PLANNING REFERENCE: PREAPP/23/00277

DEVELOPMENT PROPOSED: Currently a small 3 bedroom detached house in need of complete refurbishment including repairs, looking to propose a two storey extension to create a 4 bedroom house suitable for modern living or complete rebuild.

LOCATION: Llwyntidman Lodge, Maesbrook, Oswestry, Shropshire, SY10 8QB.

SCALE	PAPER SIZE	DATE	DRAWING	CLIENT	DWG No.
1/100	A3	Oct 23	Proposed Plans	Mr R Wrisdale	010

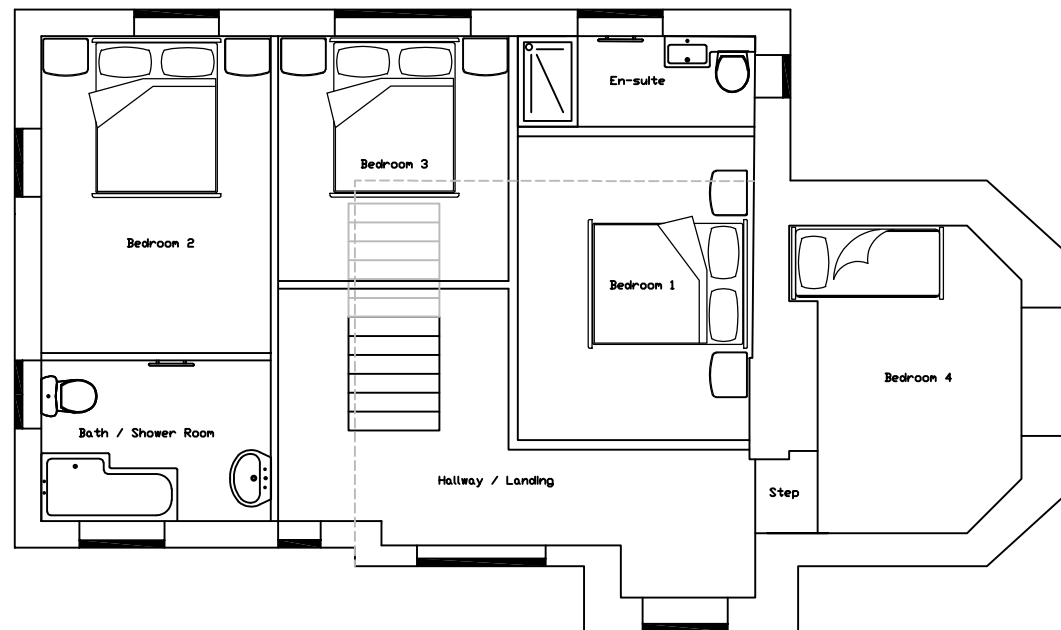
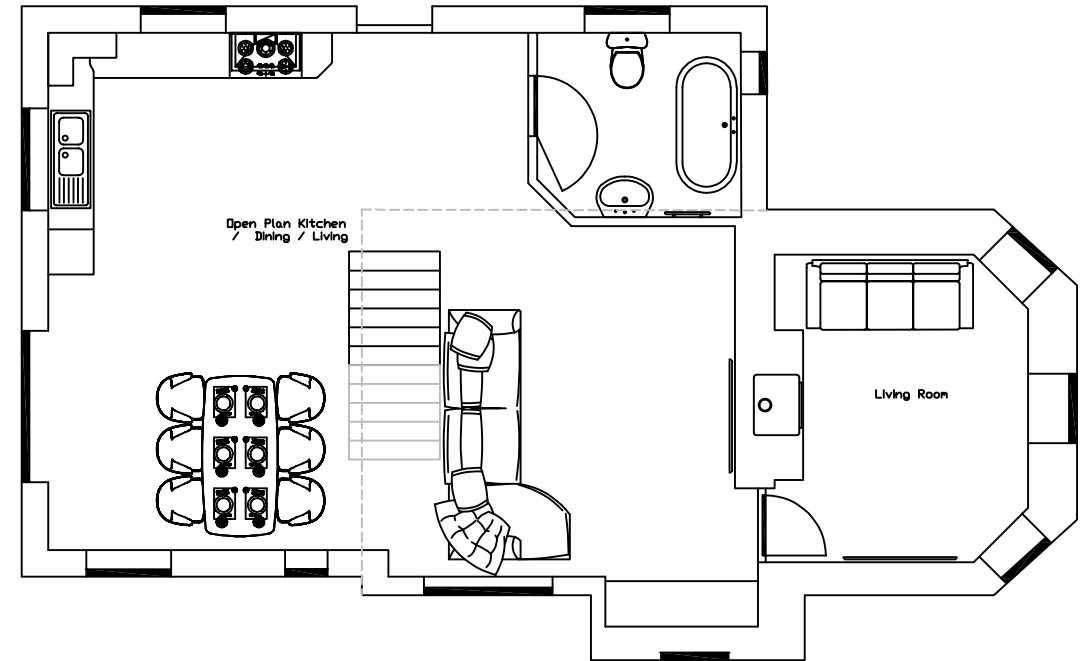
It is considered that an extension may be possible at the site, however the proposed scale is not subservient or sympathetic to the original dwelling.

It is considered that a side extension may be the most appropriate in this instance, however an extension off of two elevations would not be supported.

It is noted in the latest scheme that the height of the original cottage would be raised, however this also would not be supported. Consideration could be given to stepping down the proposed extension by cutting into the ground.

Consideration could also be given to revising the internal layout to achieve the internal space required.

Having discussed the application with the conservation officer they concur with the concerns regarding scale, massing and design of the proposed development. They have also stated that the gable of the proposed extension does not reflect the original dwelling. They consider that the design, scale and massing does not complement or
